Site: 2 – 4 Waterloo Square, Bognor Regis
Status: Full Planning Application
Reference: BR/282/19/PL
By: D. Edwards
Date: 31st January, 2019

Drawing No.	Rev.
2020-6153-002	B

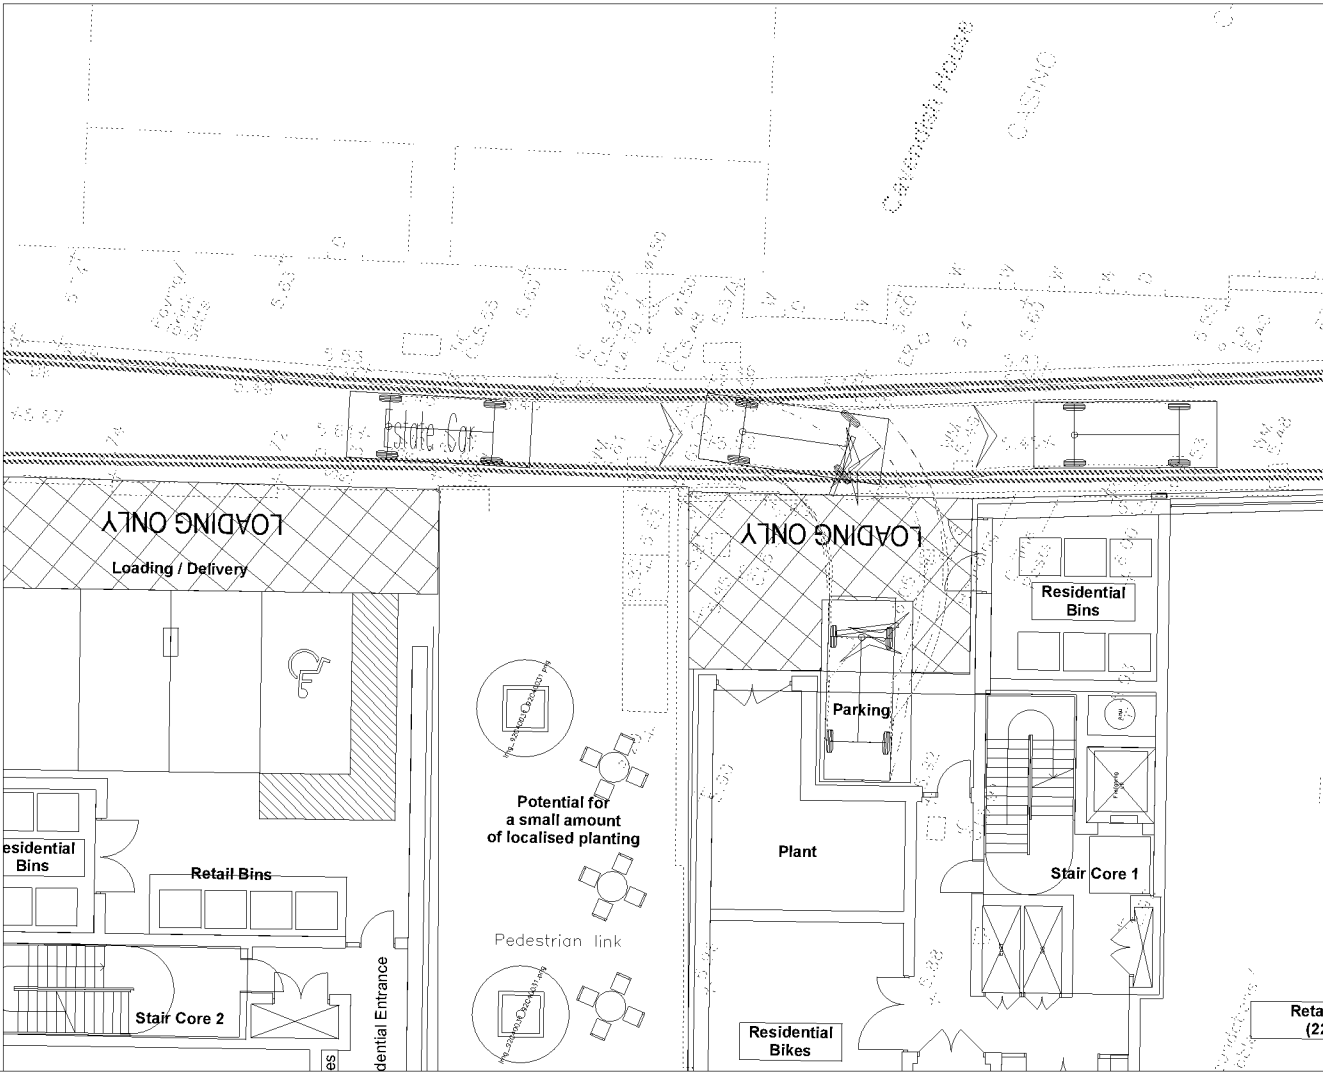
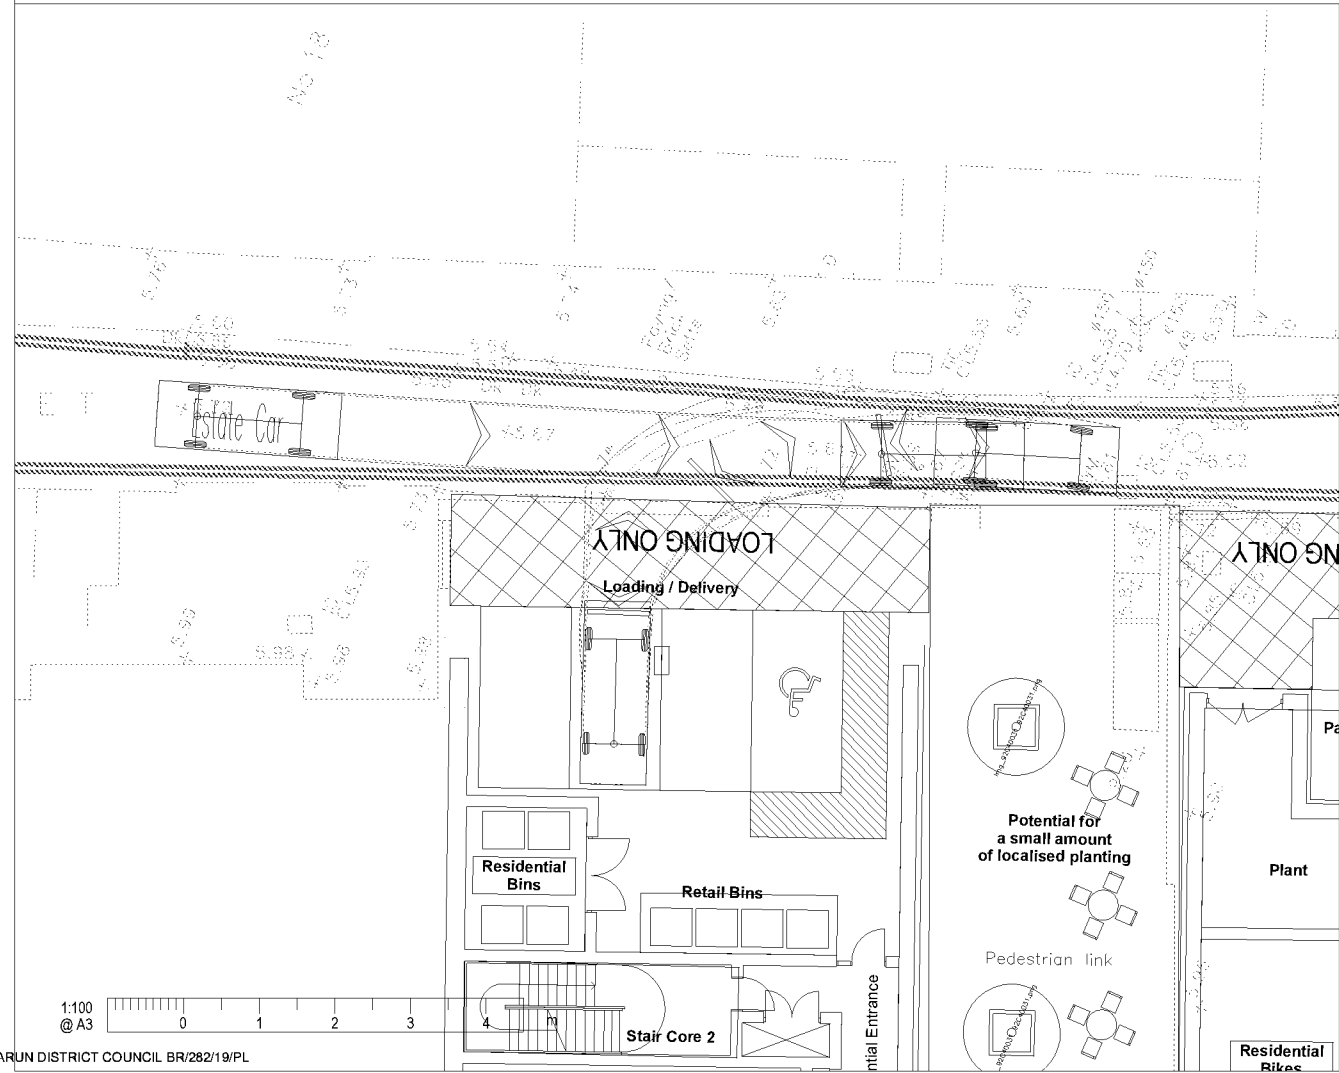
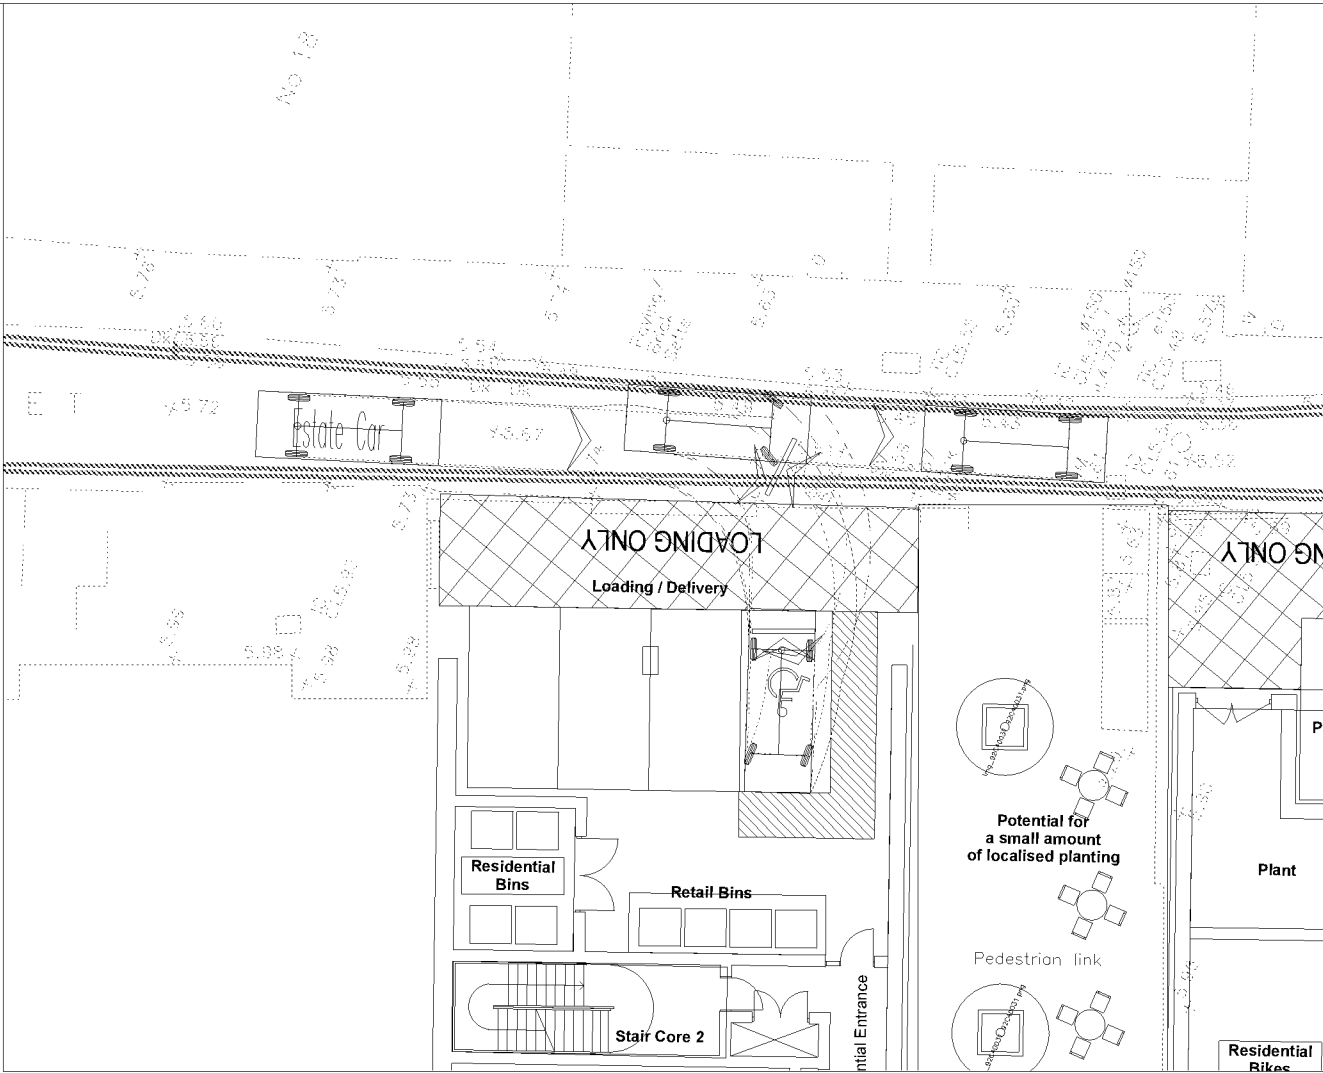
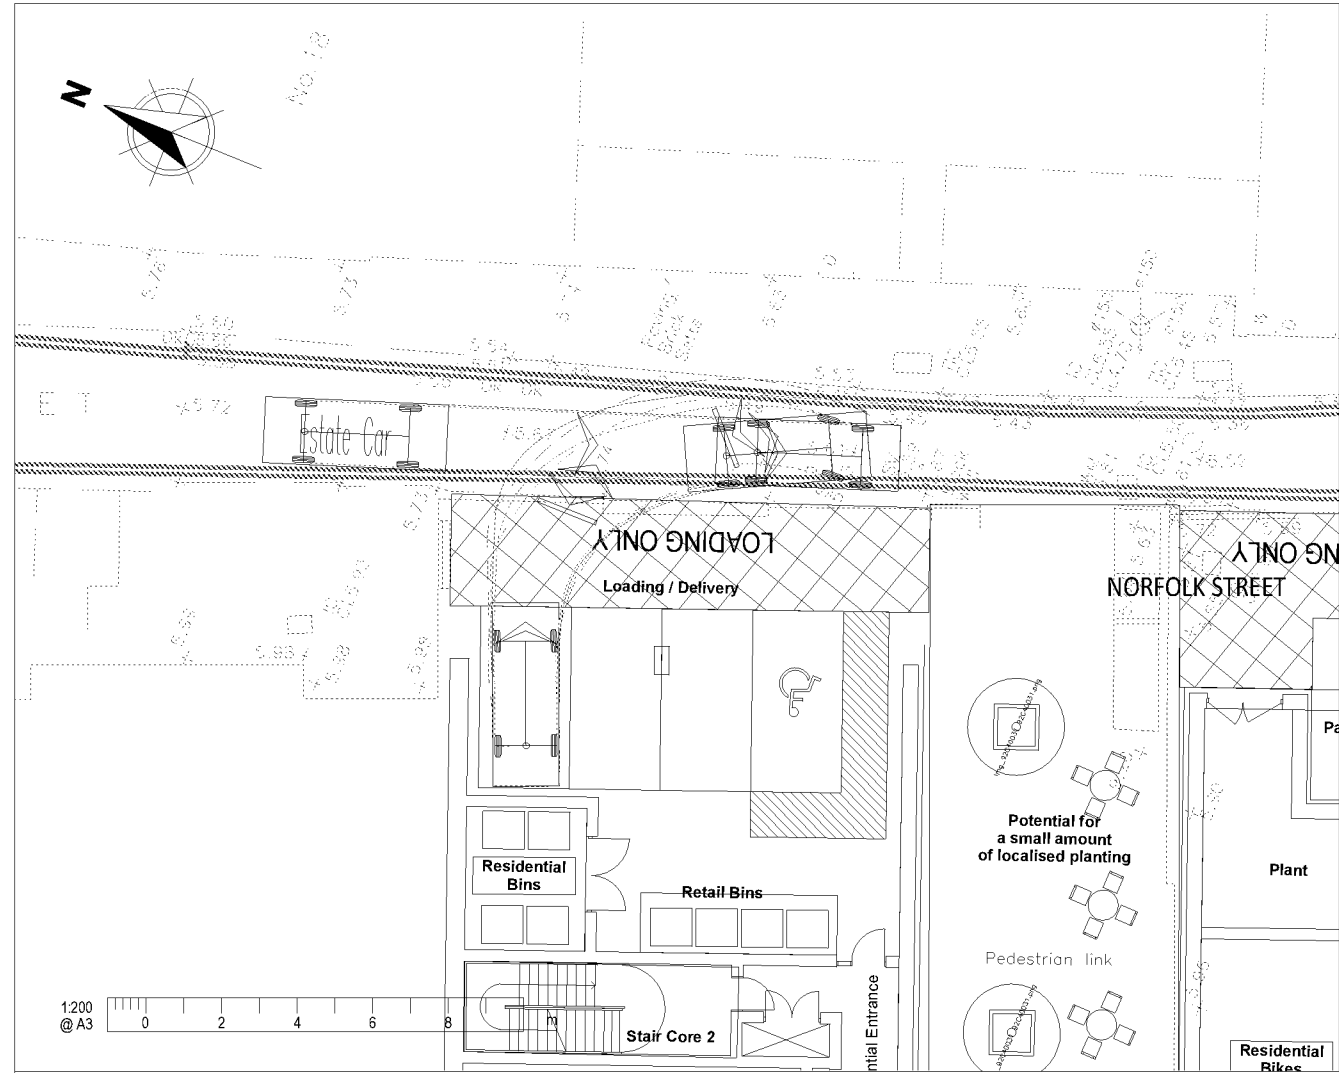
- e) Green roof – this does not appear to be incorporated in the current plans/ section.
 - f) Sweep path of service vehicles along Norfolk Street.
 - g) Viability of a single lane access ramp to sub-level parking and the potential impact of waiting vehicles on wider traffic flows around Waterloo Square.
